Please ask for: Nicola Moore
Email: nicola.moore@arun.gov.uk
Telephone: Ext 37944
Our Ref: BR/19/21/HH
Your Ref:
Date: 29th January 2021

Application for Planning Permission for Works or Extension to a Dwelling

Development: Loft conversion to form new second floor with roof alteration to form gable end and rear dormer projection.
Location: 34 Bassett Road Bognor Regis PO21 2JH

north

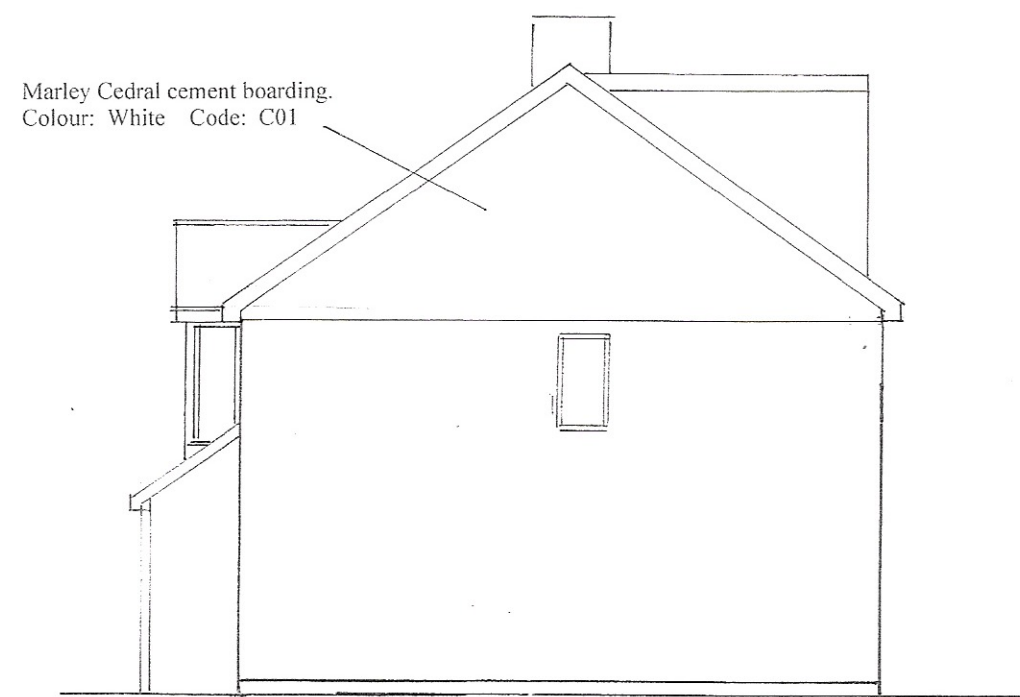
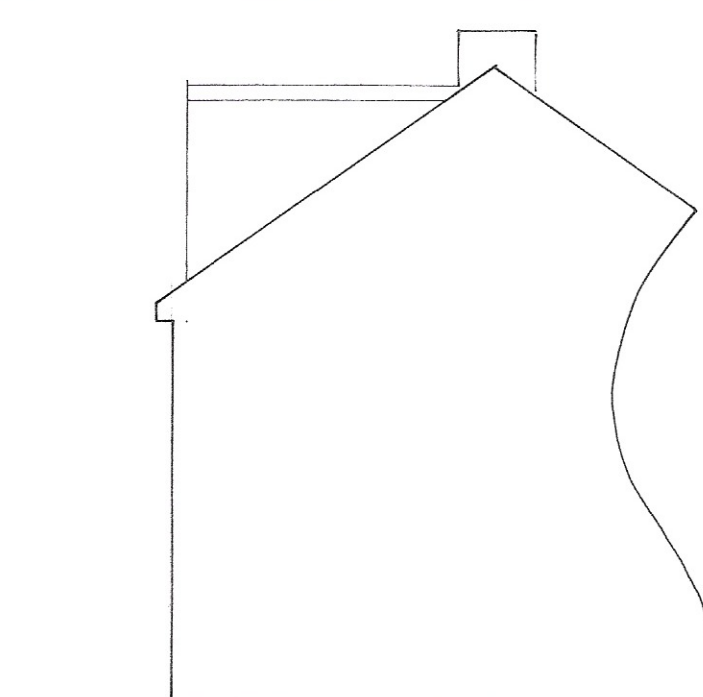
The 1st floor North elevation windows do not appear to measure the correctly. At 1:100 on the Elevations they are 2.3m and 1m, however on the First Floor plan at 1:50 they are 2.6m and 1m. Please check the measurements, amend accordingly and resubmit.
